Application No: FP/85/15/HH

Recommendation Report for Planning Permission for Works or Extension to a Dwelling

LOCATION: 18 Outerwyke Gardens
Felpham

PROPOSAL: Two storey side and single storey porch extension.

Scale: 1:125
Date: APR. 15
Drawing Number: 1202-4

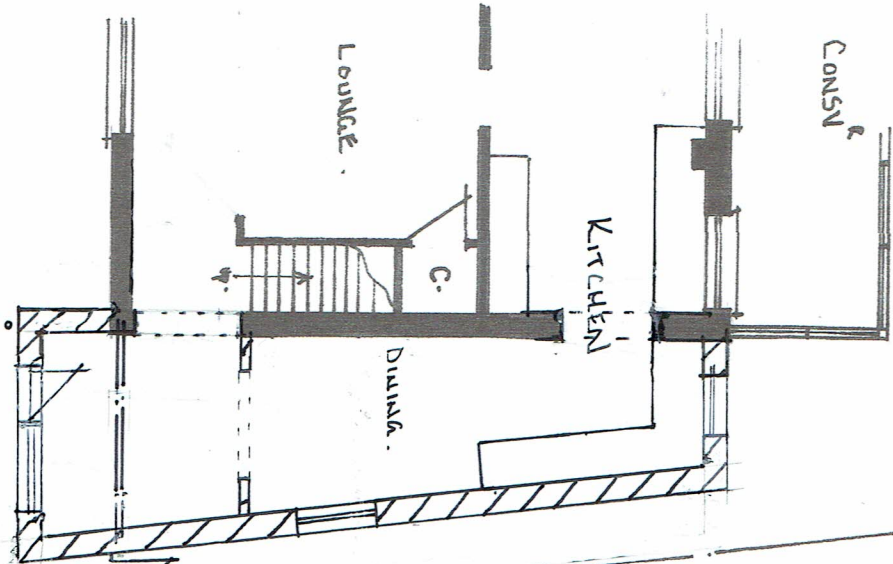
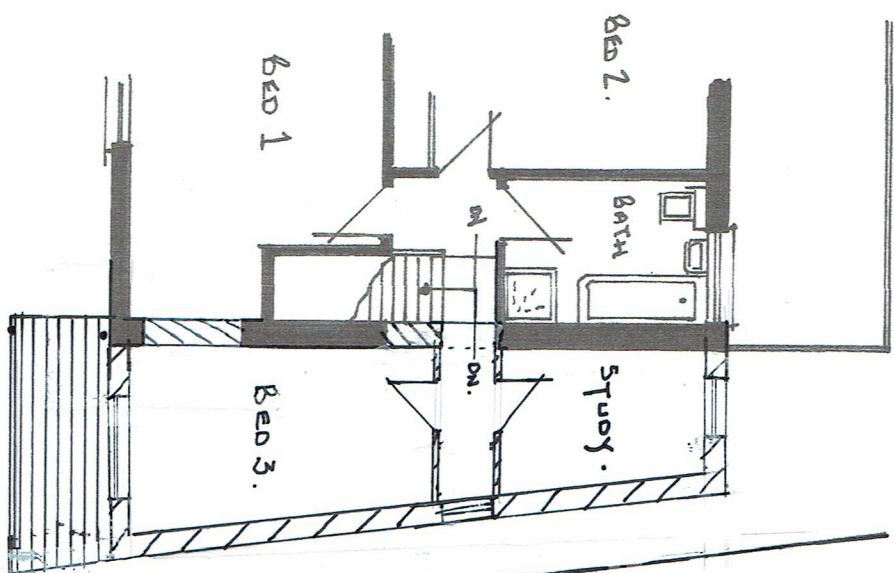
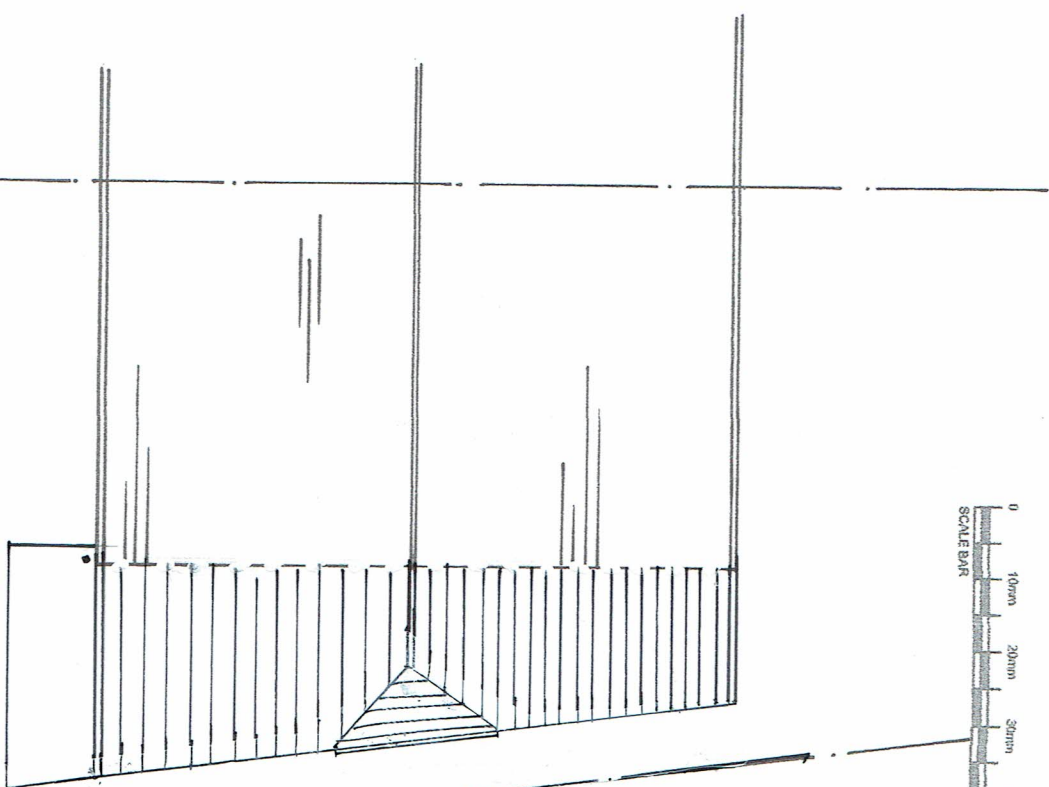
The proposed two storey extension at its widest point will be sited approximately 0.8m from the east side boundary. The main entrance to the property is sited on the east side and there is a flat roof canopy that is sited above the entrance and projects forward of the front elevation by approximately 0.8m. The proposed two storey extension which has a hipped roof will be set in line with the existing roof height and will extend along the side elevation of the property to the rear flank wall. On the east side elevation of the dwelling there are two windows at first floor level, one serves a bedroom and the other a landing area and the proposed extension has only one window at first floor level and this serves a landing area.

The main entrance is to be relocated to the front with the construction of a single storey hipped roof porch. The porch has a width of 3.4m, front projection of 1.2 and a maximum height of 3.4m. It will be constructed of brick with tiled roof to match the two storey extension and host dwelling.

The proposal is considered acceptable in design terms.

ELEVATIONS. [As Rep'd]	
Scale	1:100
Date	APR. 15 '17
Drawn By	C.R.B.
Checked	
Drawing Number	1202-5

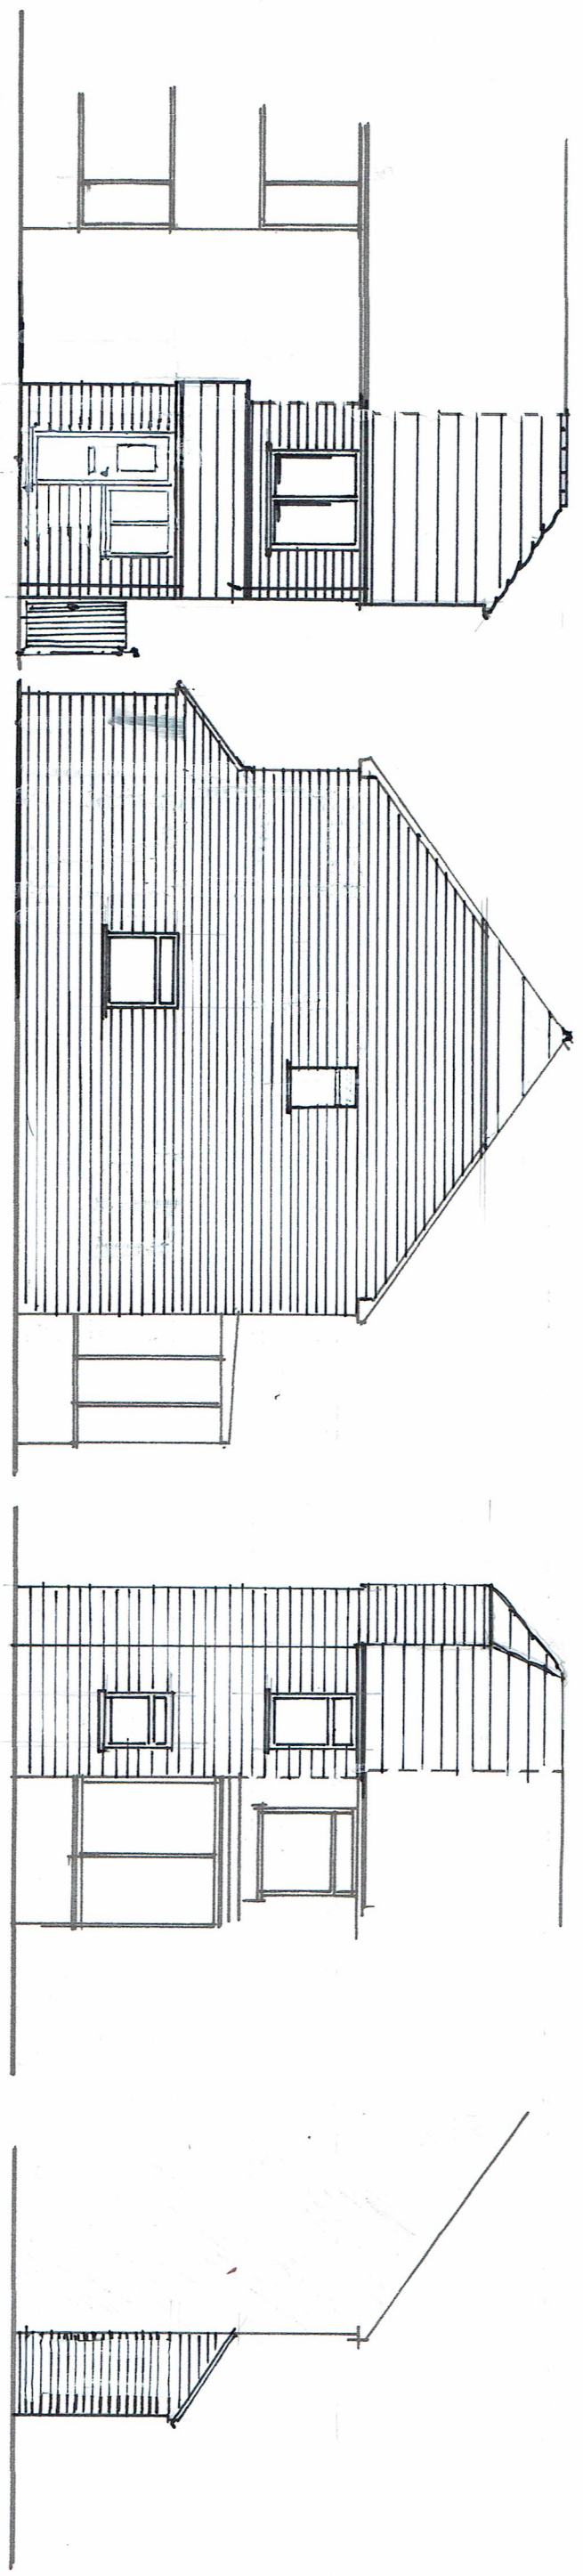
The proposed two storey side extension has a maximum width of 3m, depth of 8.2m and a height of 8.1m.

The single storey porch extension has a maximum width of 3.4, depth of 1.2m and a height of 3.4m.

- 3 The materials and finishes of the external walls and roof of the extensions hereby permitted shall match in colour and texture those of the host dwelling.

SITE LOCATION & BLOCK PLANS			
Scale	1:1250 - 1:500	Drawn By	ACB
Date	27/03/2015	Checked	CB
Drawing Number	1202 - 01A

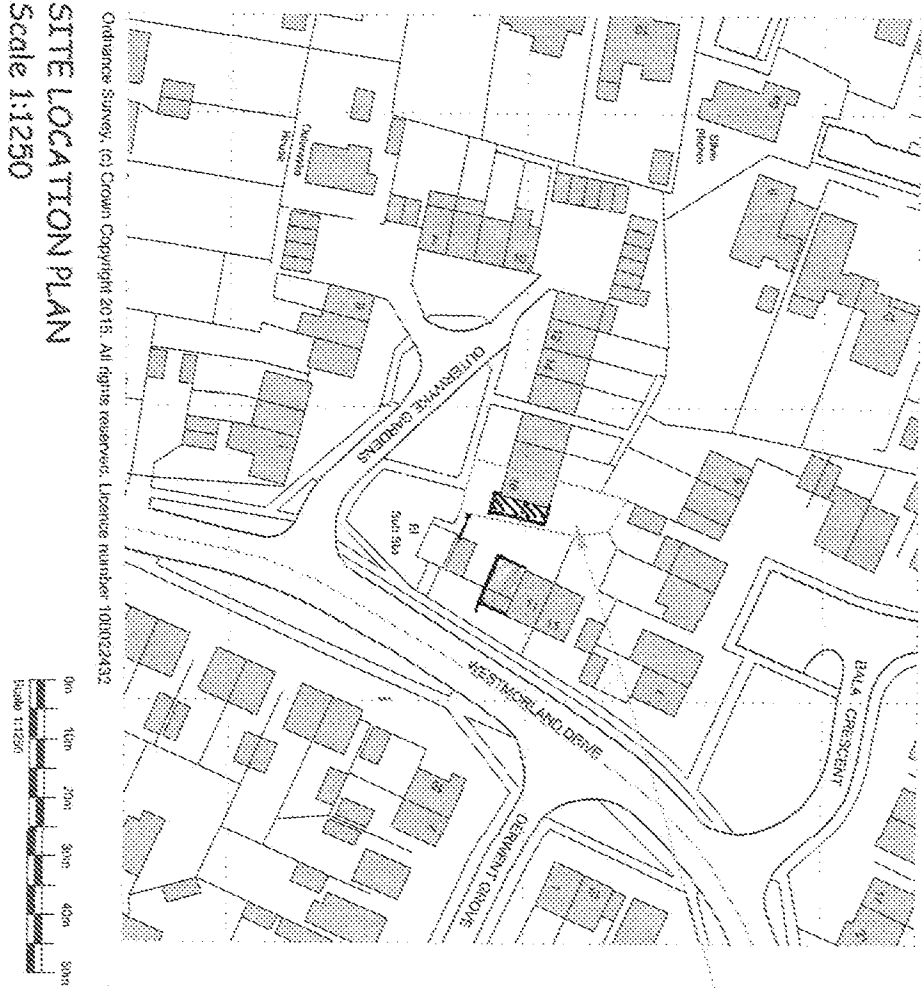
Amended Site/Block plan received on 25.6.15 showing siting of newly constructed property to east of site.

First floor should be 1m back from boundary. This application shows a gap of 0.8m at its widest point.

The plans condition item 2 has been amended to reflect this substitute plan.

The proposed extension although sited within 1m from the neighbouring boundary is not considered to compromise the character and pattern of the street scene or have a terracing affect which would be contrary to Policy DEV19(iv) of the Arun District Local Plan. See conclusions section of the officers report with regard to residential amenity.
